One Earth Solar Farm

Applicant's Response to Relevant Representation Responses

Document Ref: EN010159/APP/9.25

September 2025

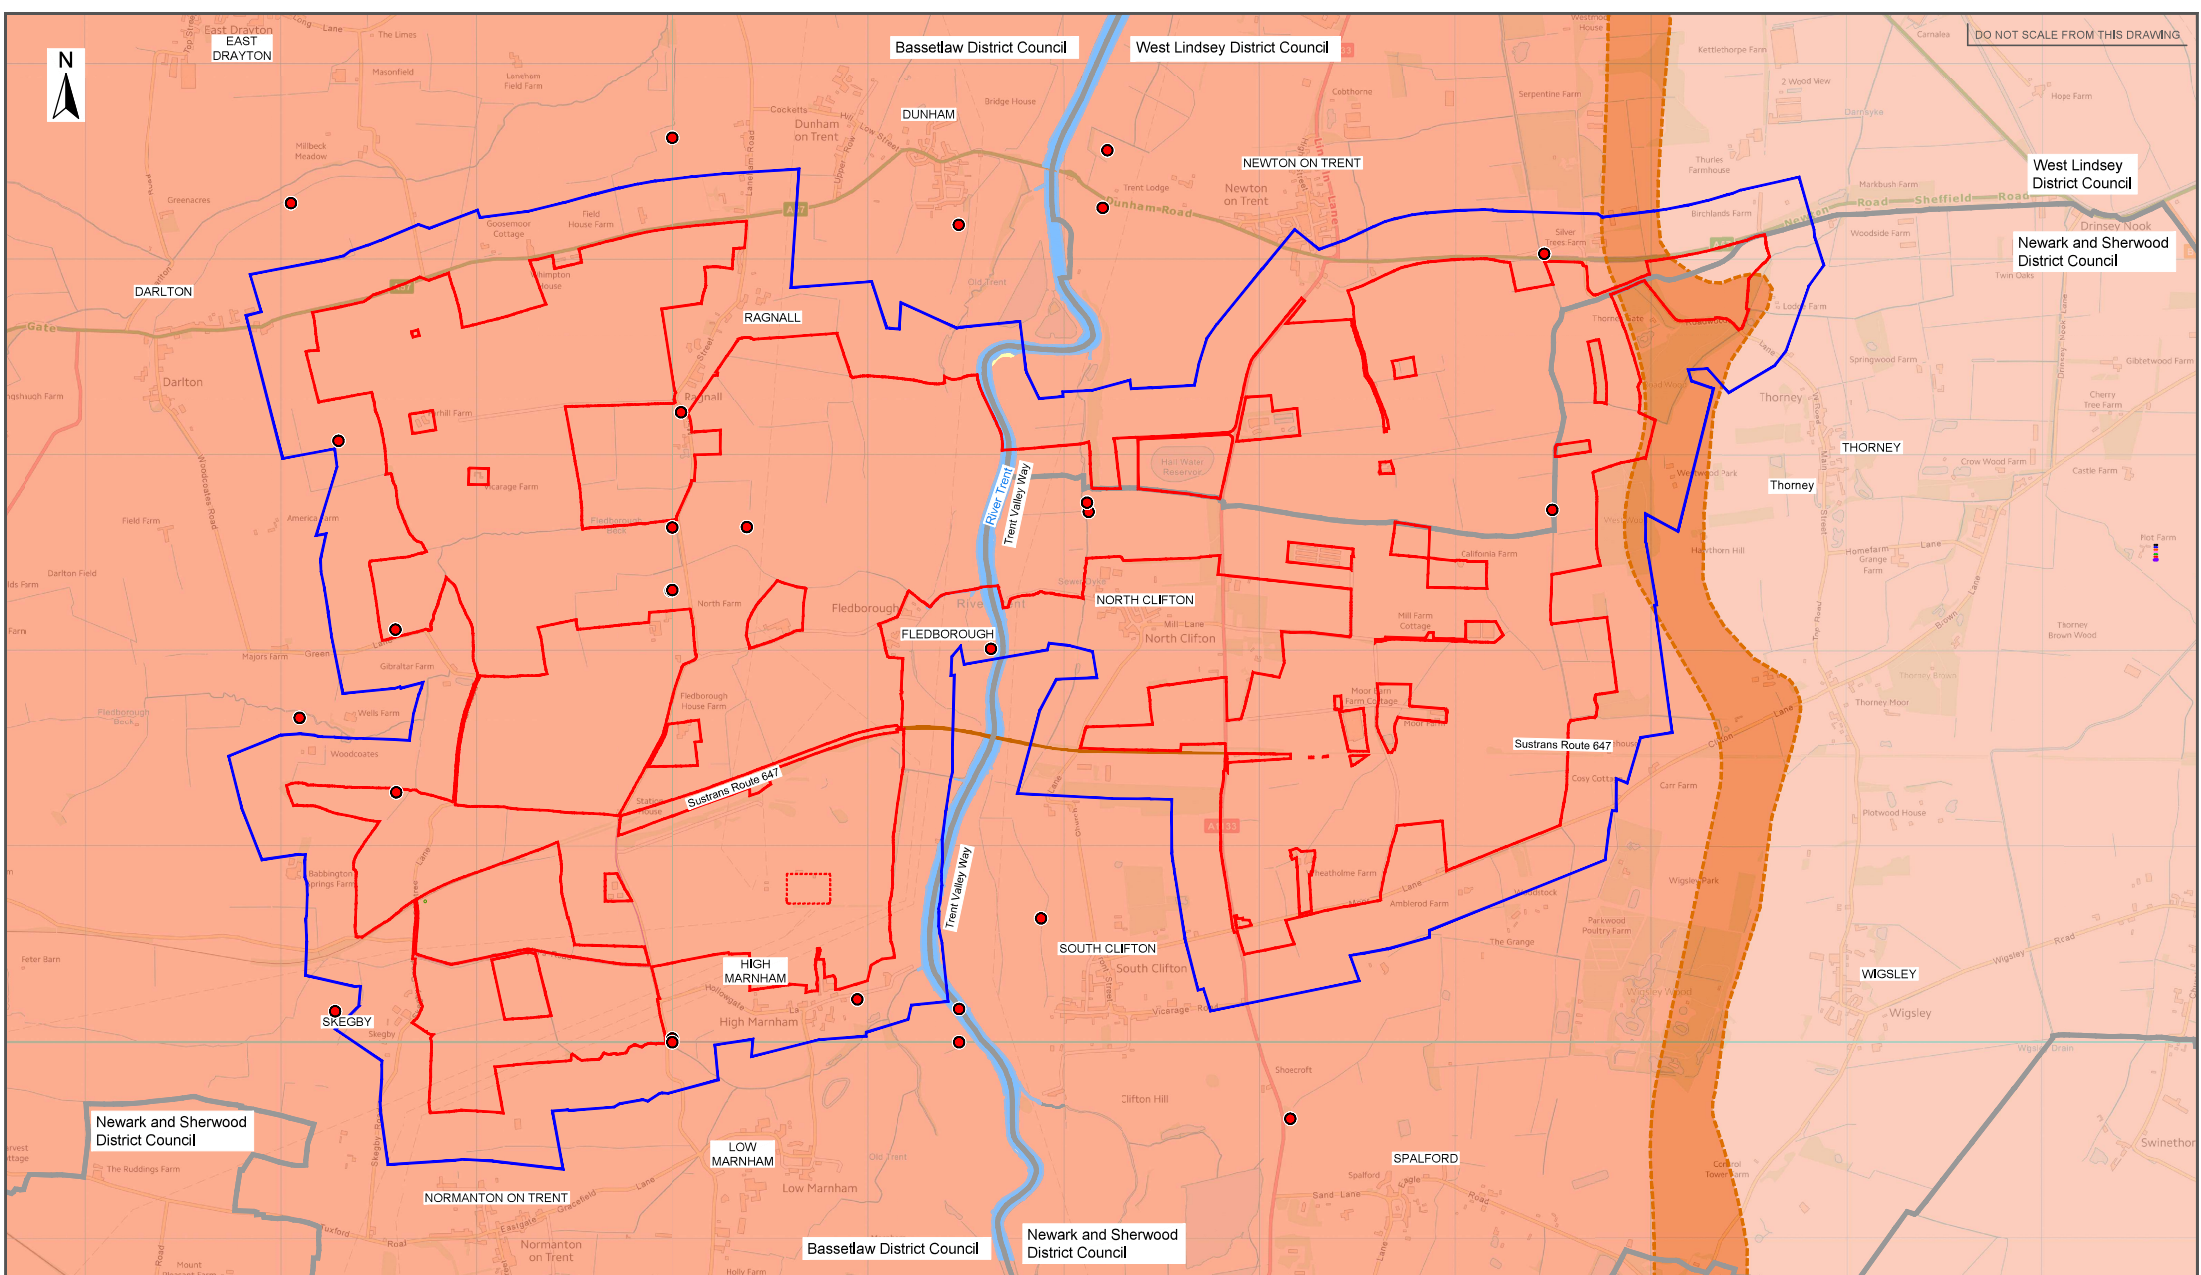
App Ref	Ref	Respondent	Question Summary	Applicant Response
			roughness patches; although OE later quantified upstand volume, EA asked to see the calculations and recommended flood flow directions be included in the model to add weight to the assessment. It remains uncertain whether these steps were completed.	
Replacement and Maintenance				
RRR12	[REP2-109]	Heather Fox	During construction, operation and decommissioning water will be encountering the metal upstands, most likely galvanised steel. What is the allowance for the inevitable corrosion of these and needing to be replaced?	Table 2-2, Indicative Design Life of Scheme Components in the Outline Operational Environmental Management Plan (oOEMP [REP2-051]) provides the indicative design life of racking and mounting systems, replacement is not anticipated because the design life is for the full operational period.
Land and Soils				
RRR13	[REP2-109]	Heather Fox	Land and Soils Table 8.1 states ` There are no recorded current or historical landfill sites within the site`. The EA states, ` Our records show that there are two historic landfills associated with the High Marnham Power Station present within the site boundary - waste was accepted there 1978-1994. These should be given some consideration`. Have these potential sources of contamination been included elsewhere?	It has not been possible to identify the Table 8.1 referred to here. The relevant chapter of the Environmental Statement (Chapter 8: Land and Soils, EN010159/APP/6.8 [APP-037]) and supporting appendix for the ES chapter (Appendix 8.2 Preliminary Risk Assessment, EN010159/APP/6.21 [APP-099 to APP-104]) refer to the existence of two historical landfill sites close to the location of the former High Marnham Power Station. One is in the location of the former sewage treatment works, which is within the Order Limits, and the other is close to the location of the former station buildings at Clifton railway station, which is outside the Order Limits. The locations of these features are shown on Figure 8.2 (Environmental Statement Volume 3, EN010159/APP/6.20 [APP-054]). It should be noted

App Ref	Ref	Respondent	Question Summary	Applicant Response
				<p>that earlier revisions of Figure 8.2 did show the landfill site at Clifton Railway Station to be partially within the Order Limits. This is not the case, and the correct boundary for the landfill is now indicated on Figure 8.2, which shows it to be outside the Order Limits.</p> <p>The available detailed information relating to these two historical landfill sites is presented in Appendix 8.2 Preliminary Risk Assessment, EN010159/APP/6.21 [APP-099 to APP-104] in Table 6 (page 9). These locations are considered by the assessment of potential environmental impacts within Chapter 8: Land and Soils, EN010159/APP/6.8 [APP-037], in terms of the potential for impacts during construction (see Section 8.6.2 for impacts to land and Section 8.6.7 for impacts to groundwater), operation and maintenance (see Section 8.6.37 for impacts to groundwater) and decommissioning (see Section 8.6.53 for impacts to land and Section 8.6.55 for impacts to groundwater). The environmental impact assessment concludes that there are no significant effects as a result of the Proposed Development in relation to contamination from existing sources.</p>
